East Anglia One North (EA1N) and East Anglia Two (EA2) Offshore Wind Farms

Planning Inspectorate Reference: EA1N – EN010077, EA2 – EN010078

Deadline 11 – 7 June 2021

**Comments of Suffolk County Council as Lead Local Flood Authority**

TYPICAL INFILTRATION BASIN CROSS SECTION

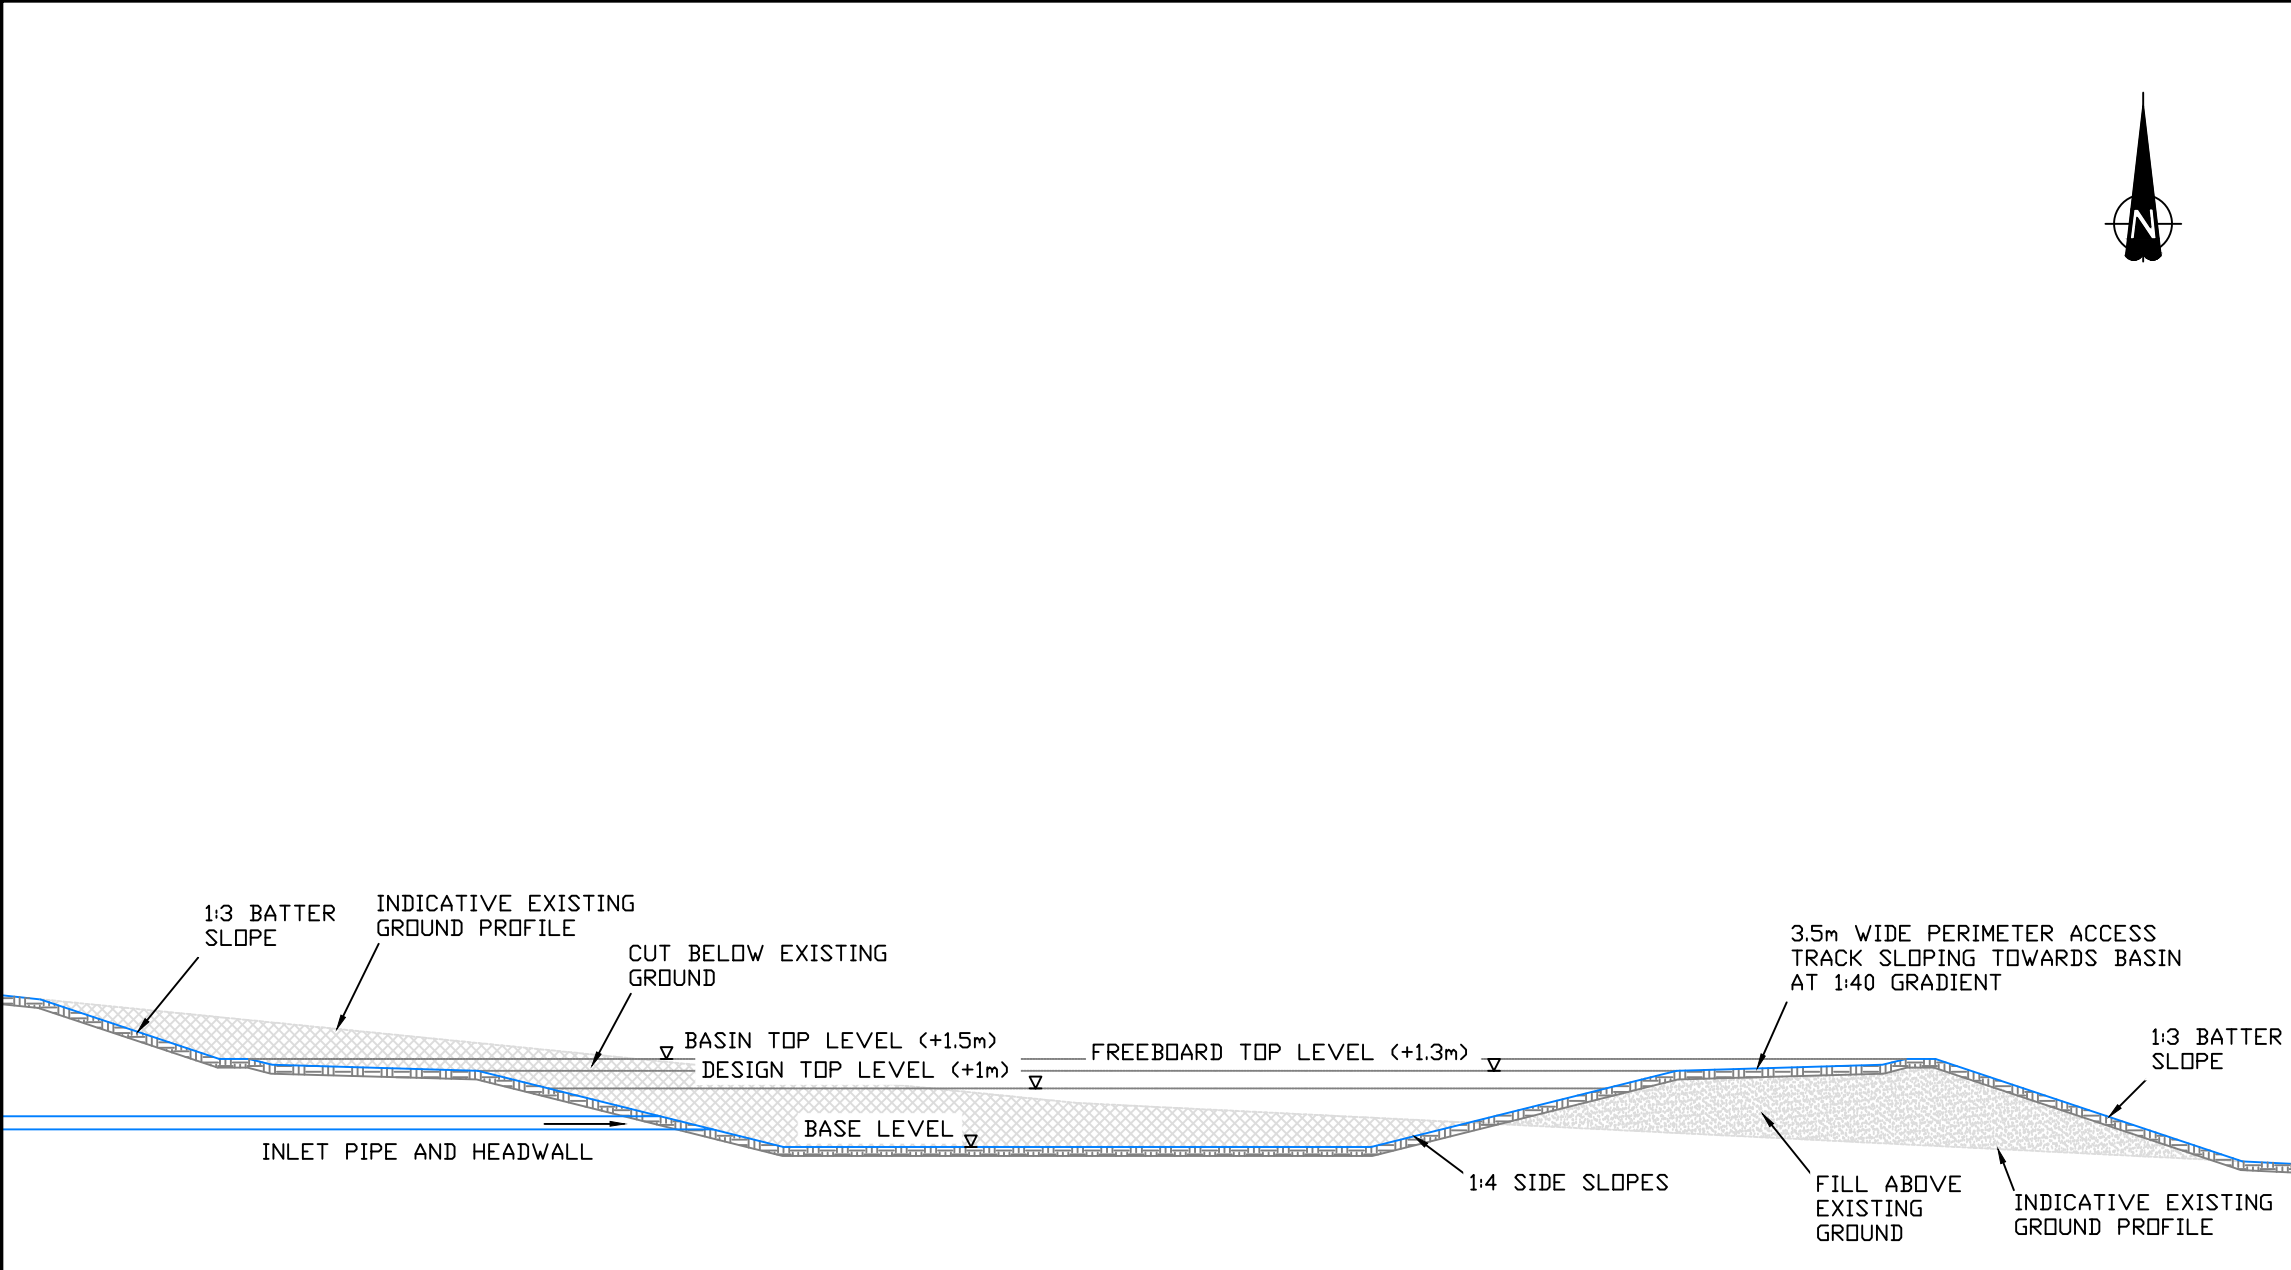
Total basin depth = 2.0m.

This exceeds the CIRIA SuDS Manual guidance of a maximum total depth of 1.5m for basins.

It is unclear why 2.0m depth is required if water levels are not exceeding 1m?

Water depths have the potential to exceed 1m, when 1:100+40% is combined with 1:10+40% after 24 hours, however, no assessment of this has been undertaken.

Maximum water levels should be shown on future sections. This should be either after 1:100+40%, or after a further 1:10+40% storm is added after 24 hours, whichever results in the greater water level.
